Application for Planning Permission for Works or Extension to a Dwelling

Development: Alterations to external materials including replacement of tile hanging with cladding, render to ground floor walls, cladding to porch, 2 No. roof lights and replacement windows. Loft conversion with dormers to the front and rear elevations. Erection of carport and store to side elevation.

Location: Driftwood 32 Coastal Road Kingston BN16 1SJ

**Drawing Name**  
 Elevations - Proposed

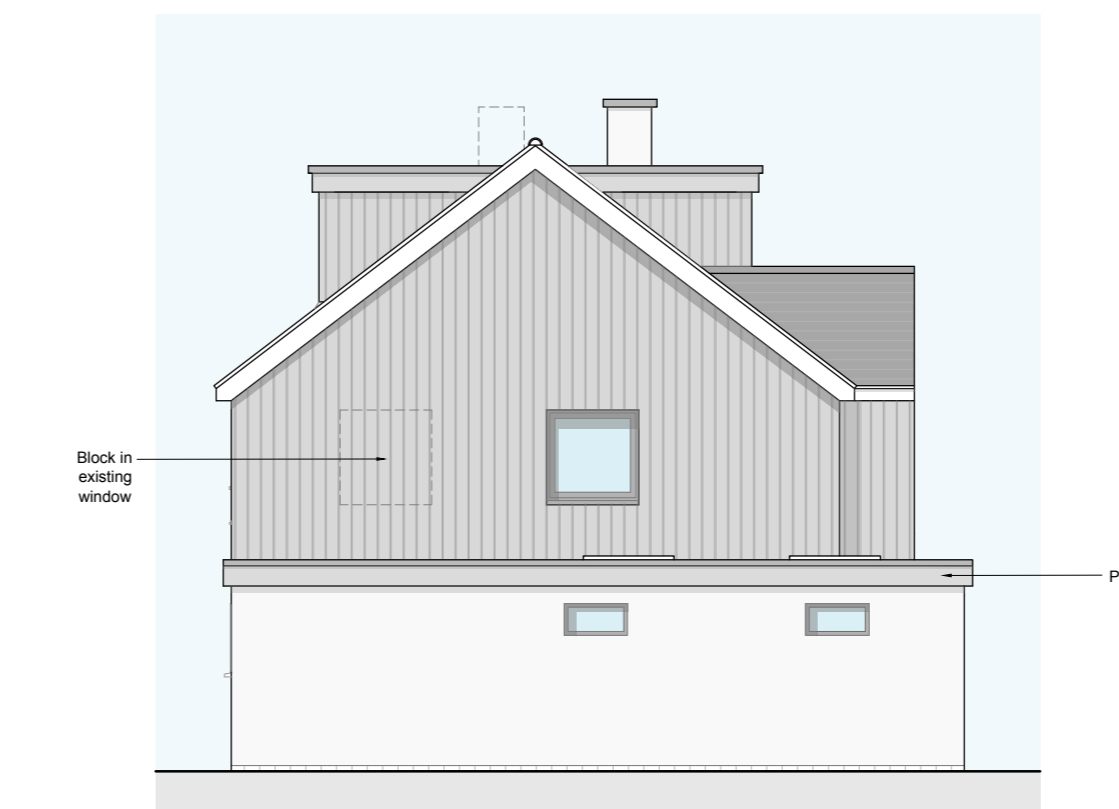
There is a door serving the store on the proposed ground floor plan that is not shown on the proposed south elevation. Please amend accordingly and resubmit.

The windows and doors serving the seating area on the proposed ground floor plan are not shown on the proposed south elevation. Please amend accordingly and resubmit.

There is a door serving the store on the proposed ground floor plan that is not shown on the proposed north elevation. Please amend accordingly and resubmit.
